# THURROCK COUNCIL

Application for a Non-Material Amendment Following a Grant of Planning Permission

Proposed replacement dwelling of a contemporary design with associated hard and soft landscaping

22/00652/FUL

Drawing **Proposed Plans & Elevations**

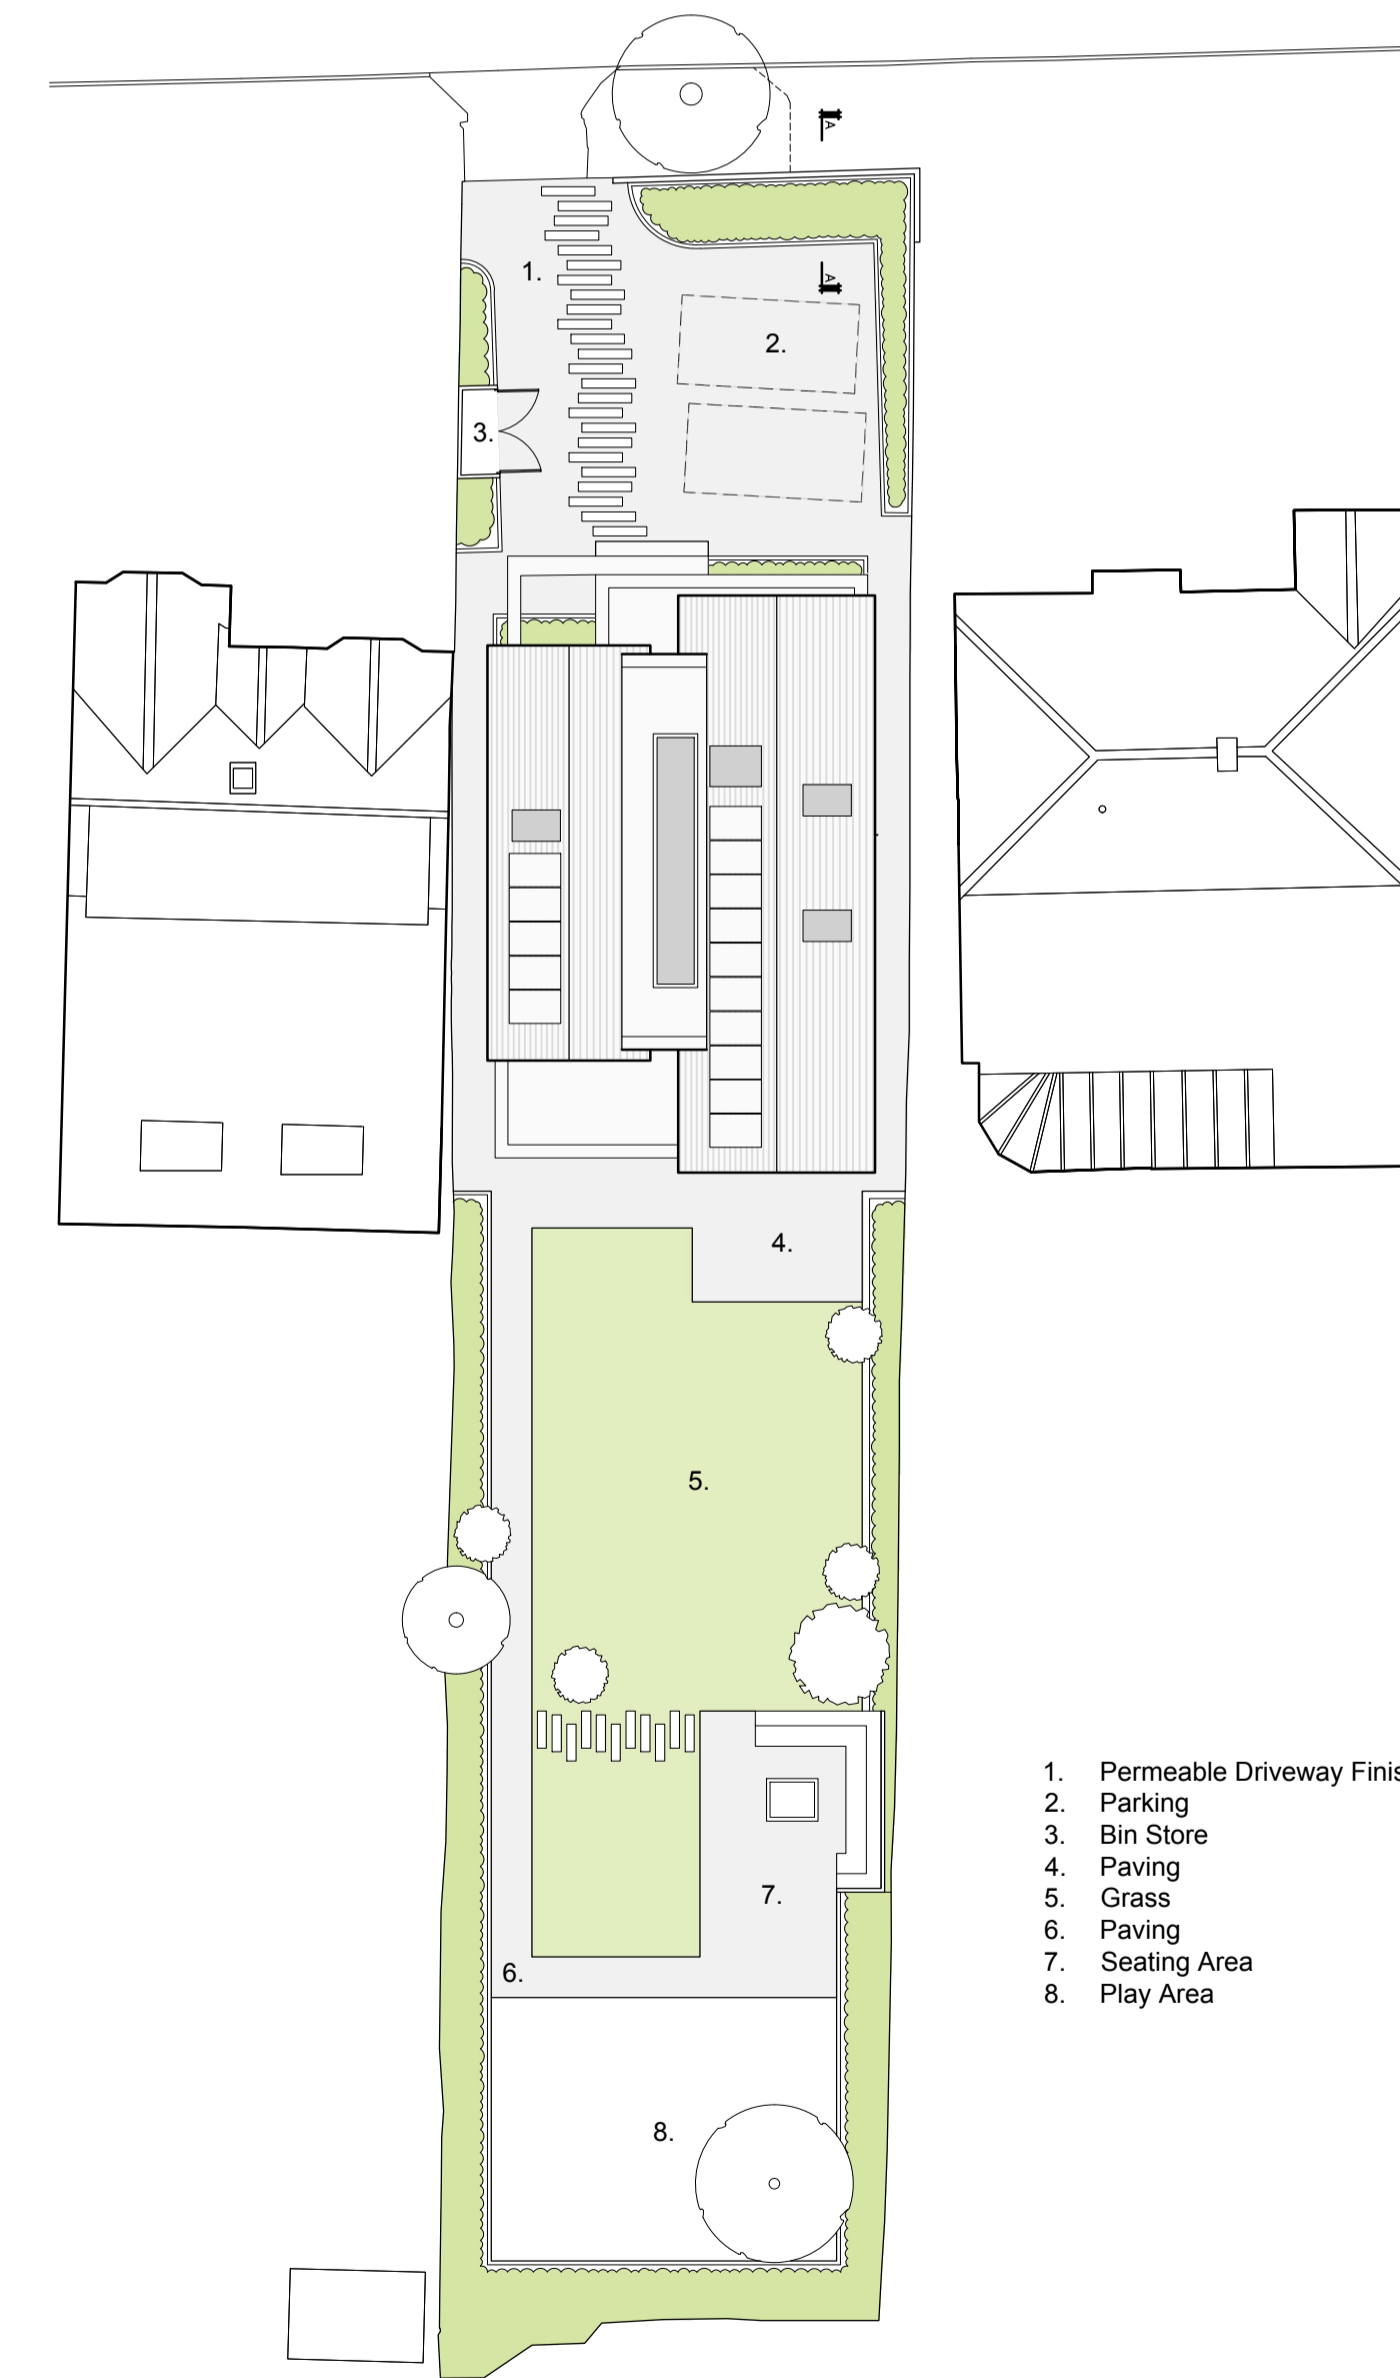
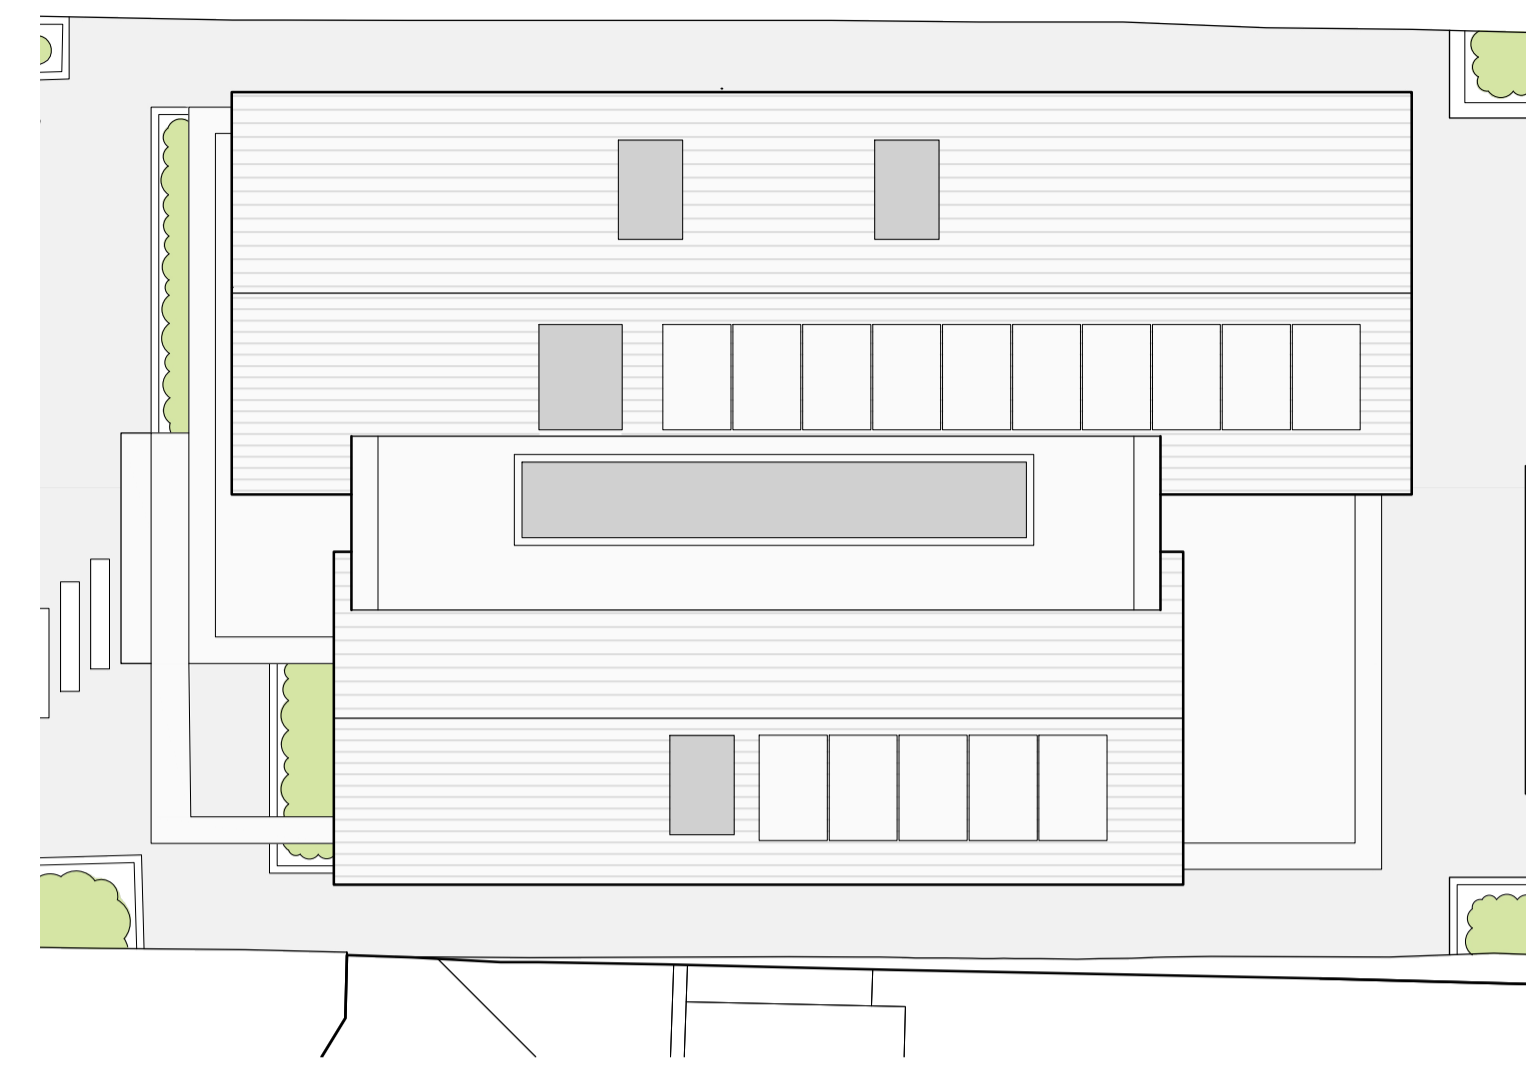
The suggested window configurations harmonise with the other openings throughout the home, ensuring a uniform design language. This layout was initially proposed in the approved planning proposal, detailed in drawing RHJB\_22002\_002E\_Proposed Plans and Elevations. We believe that opting for a fan-light arrangement would disrupt the cohesive design of the house and prevent adequate room ventilation required by Building Regulations. Instead, the proposed configuration includes obscure glass in compliance with this planning condition, alongside a window restrictor limiting the aperture to 70mm, as depicted in drawing RHJB\_22002\_011B\_Proposed North and South Elevations. We are confident that any potential overlooking concerns would be minimal, especially given the placement of these windows along a side alleyway and within a transitional zone between bedroom and en-suite spaces within the home.

RHJB\_22002\_002E\_Proposed Plans and Elevations
